Cockle Bay Park – Response to Government, Agency, and Organisation Submissions

# RL183 Tower Position Options - Axo

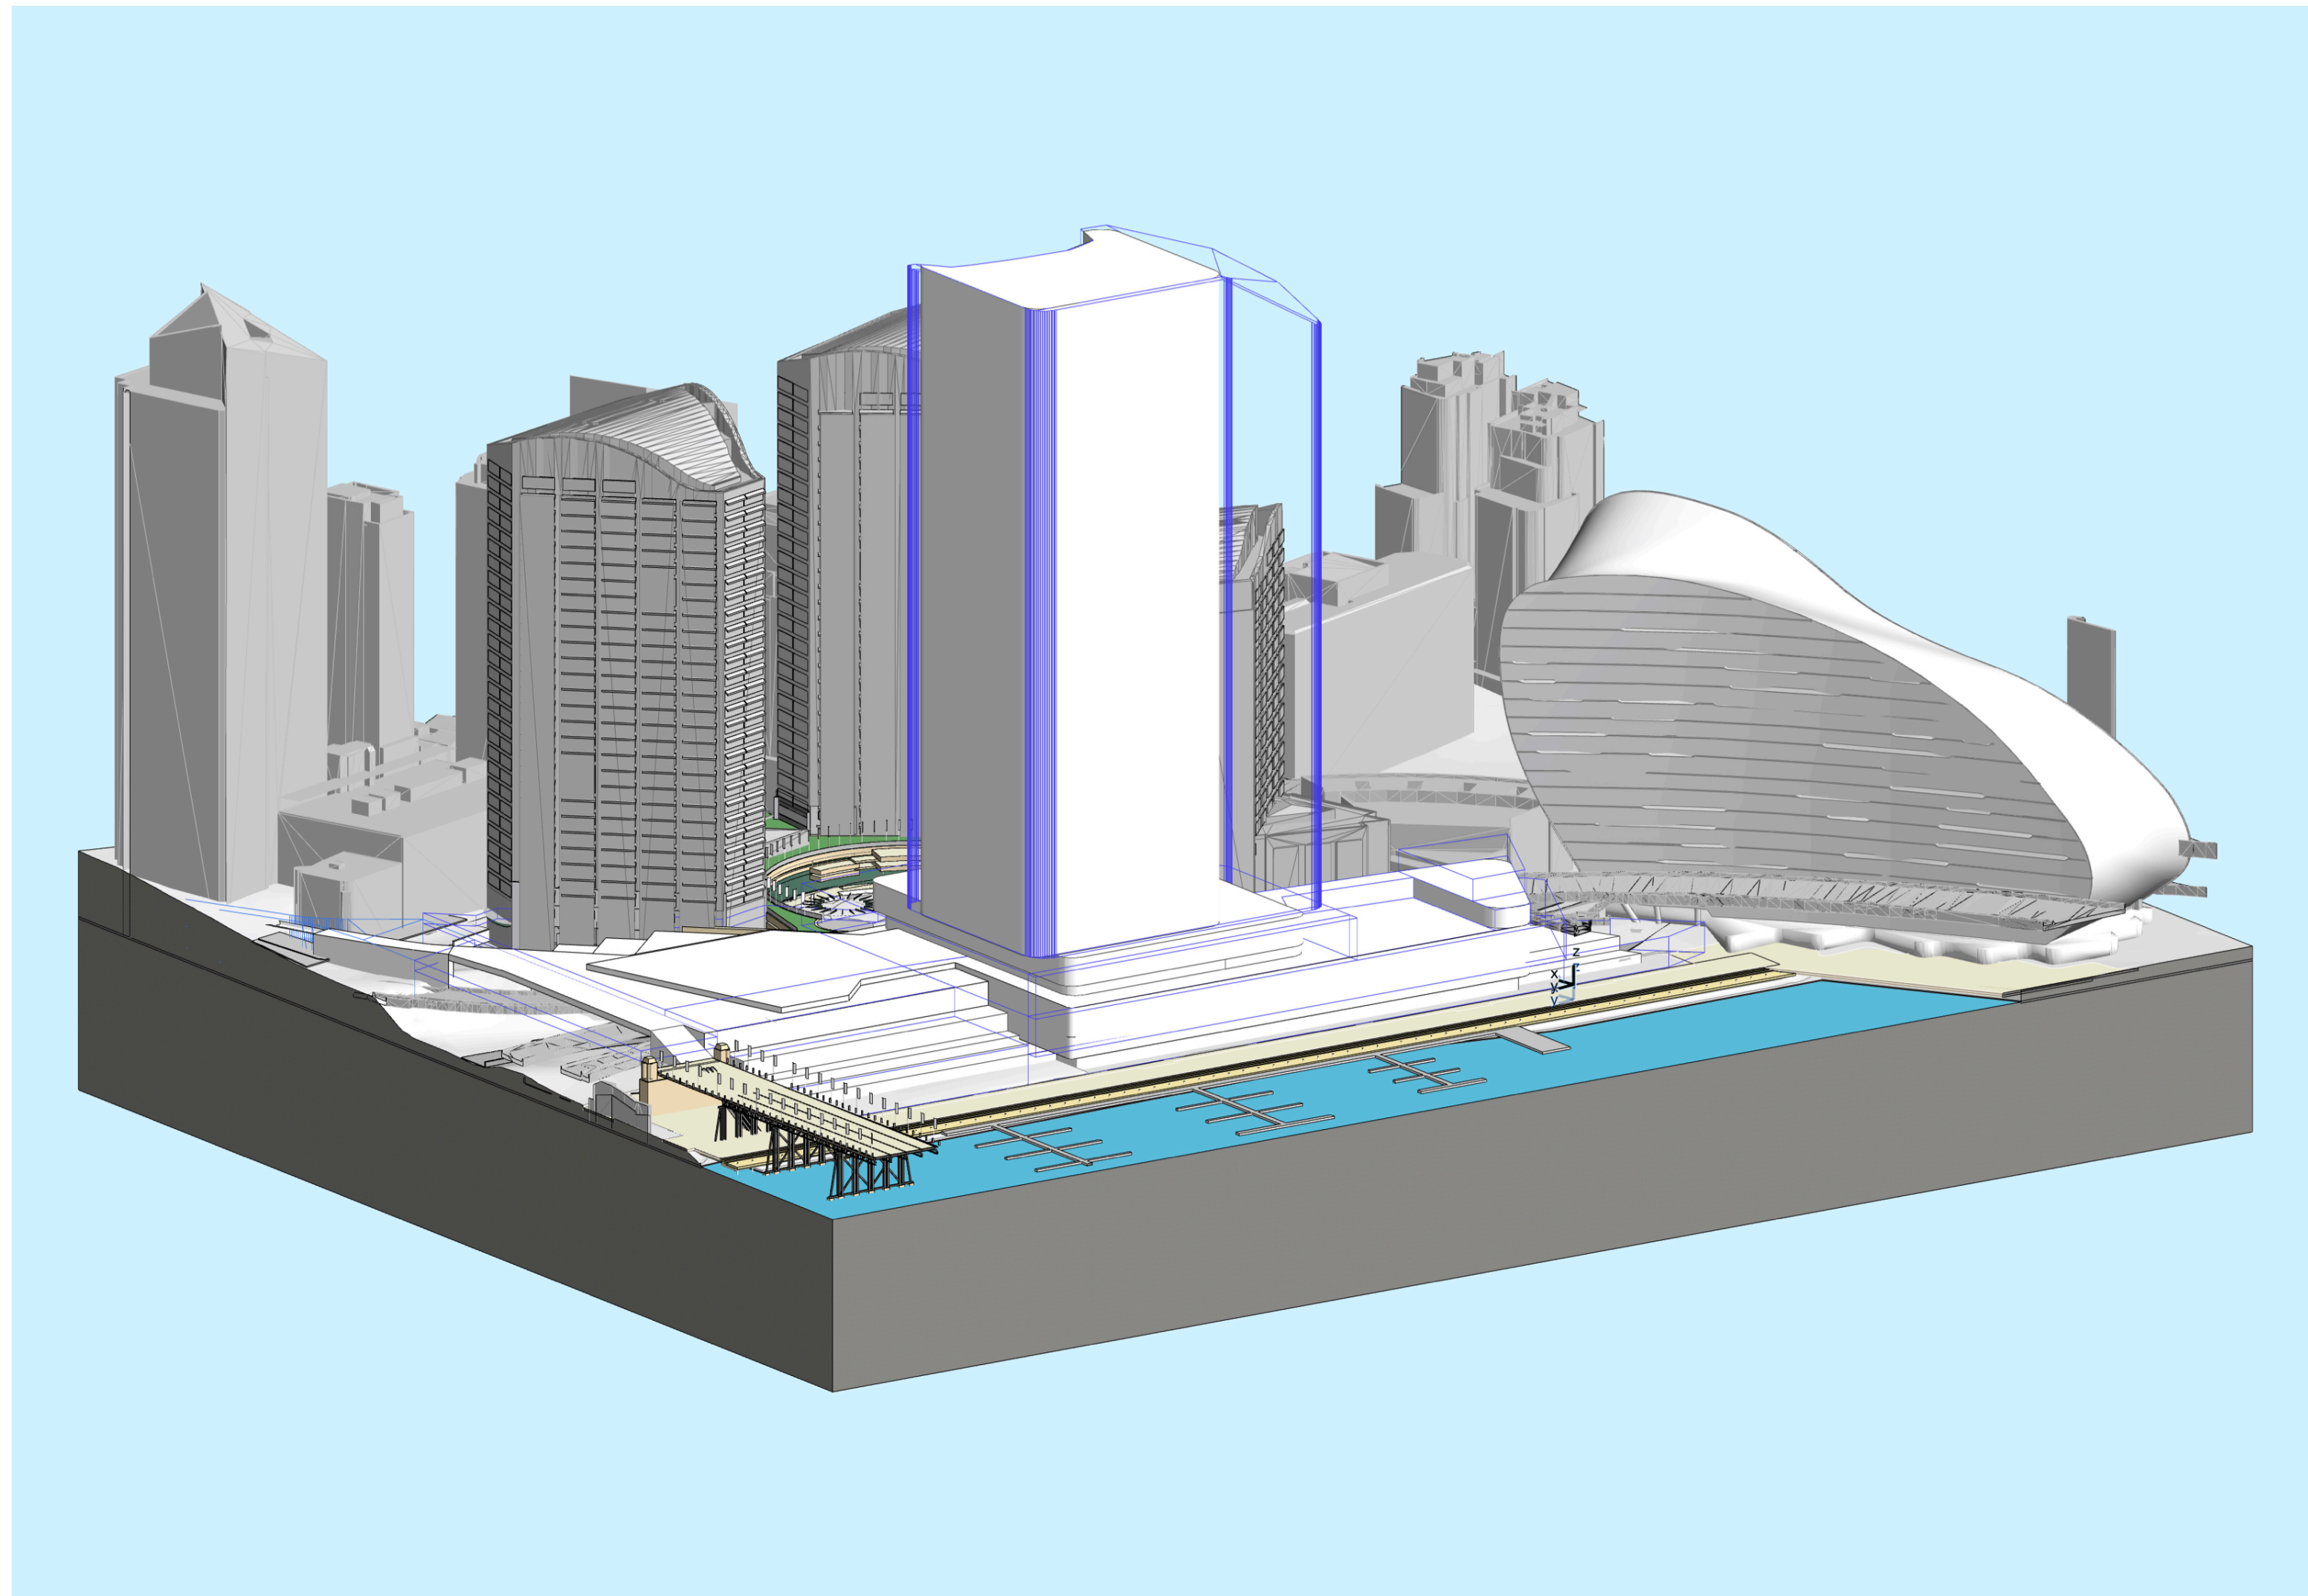
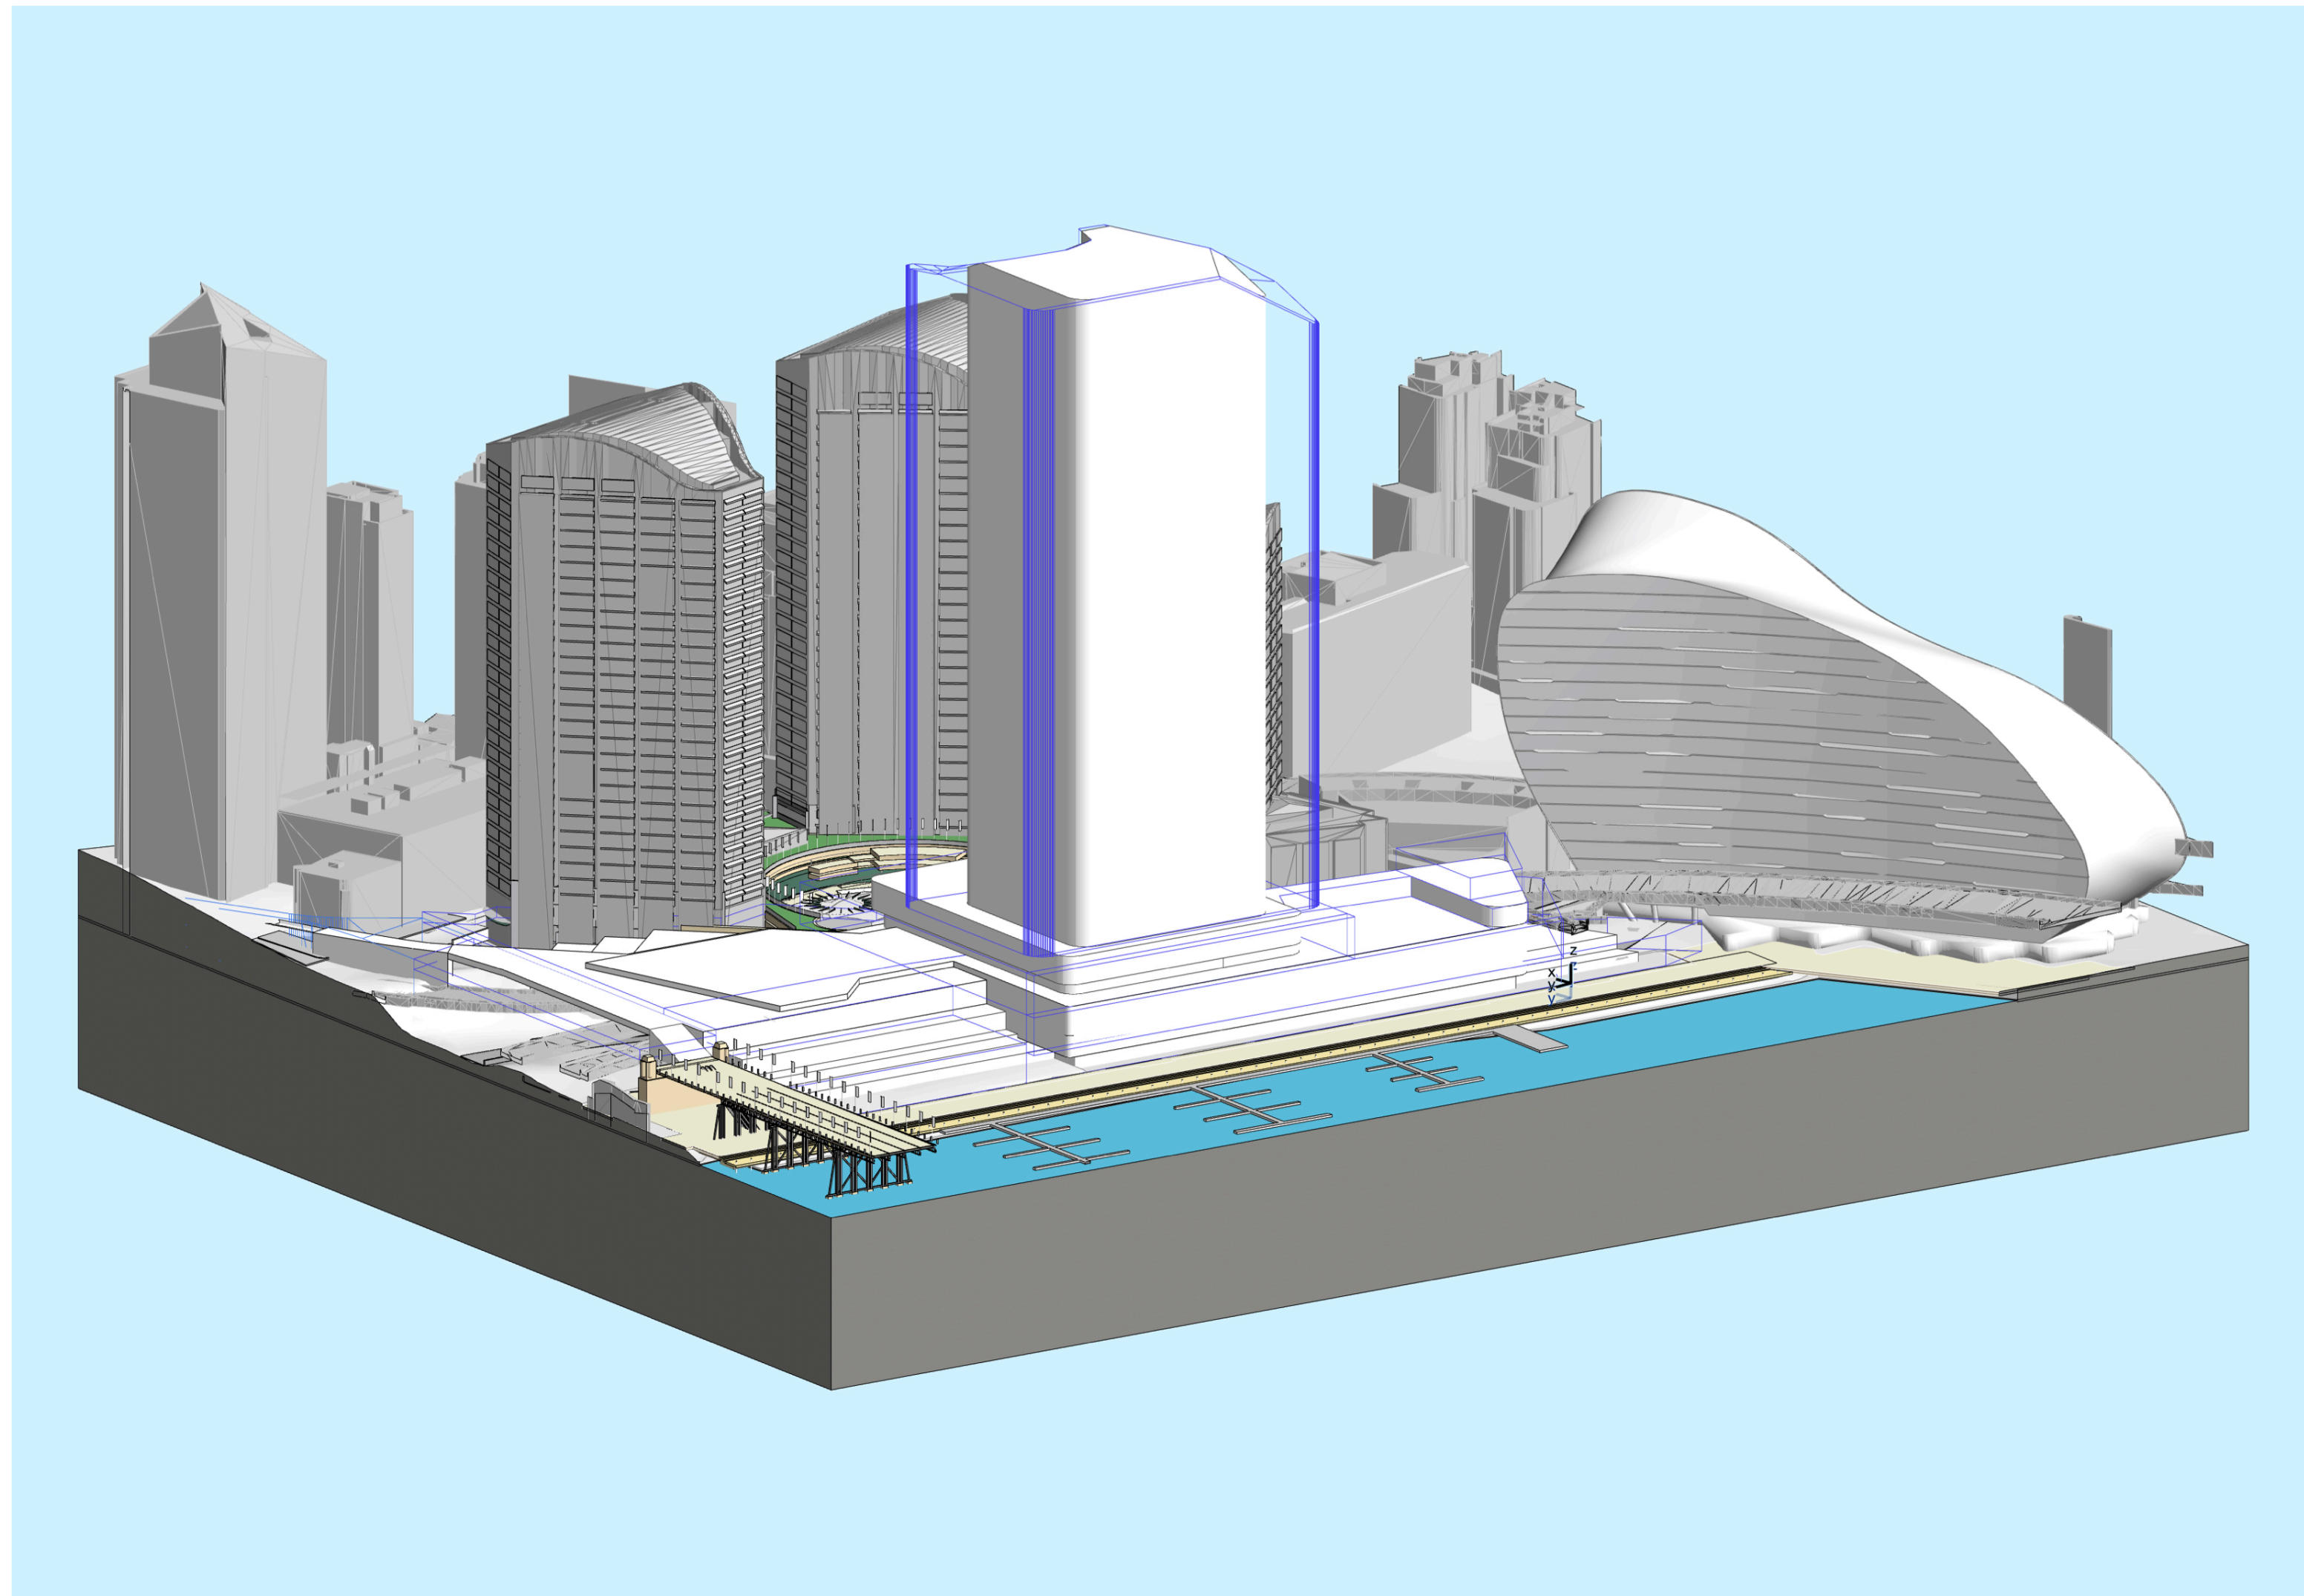
Tower Siting	
Further justify the tower location, including analysis of alternative locations considering benefits/impacts of each.	Following the exhibition of the EIS the proponent has engaged in a series of design development workshops with the Department's urban design consultant and the proponent's design excellence team. The outcome of these workshops has been documented within the Response to Submissions document (refer to Section 3.0). The location of the tower form within the site allows for flexibility of outcome through the competitive design process and therefore proposes a larger area than would be occupied by any future built

Item Raised	Proponent's Response
	<p>form. However, within the envelope various built form outcomes have been deemed acceptable where accompanied by further built form controls</p> <p>Further justification for the location of the tower envelope and built form controls has been provided within Section 5.2 and Appendix C</p>
<h3>Private View Impacts</h3>	
<p>Additional view impact analysis required, including:</p> <ul style="list-style-type: none"> - Comparative analysis of existing and proposed reduced view/cone from the Sussex St properties - Identification of the levels and units where water views and views to Pyrmont Bridge can be obtained and will be affected - Detailed response to submission from 222 Sussex St and associated view analysis - Further consideration of the tower height impacts on water views due to relative angle of depression 	<p>A supplementary View and Visual Impact Analysis has been prepared and is provided as Appendix D. This supplementary impact analysis provides an update on the previously submitted impact assessment to address changes to the design of the Concept Envelope and also includes a detailed assessment of view loss from neighbouring residential buildings where access to these apartments have been provided. This private view analysis has had regard to relevant Planning Principles for View Impacts. Refer to Appendix D and to Section 5.4 of the RTS for additional information.</p>
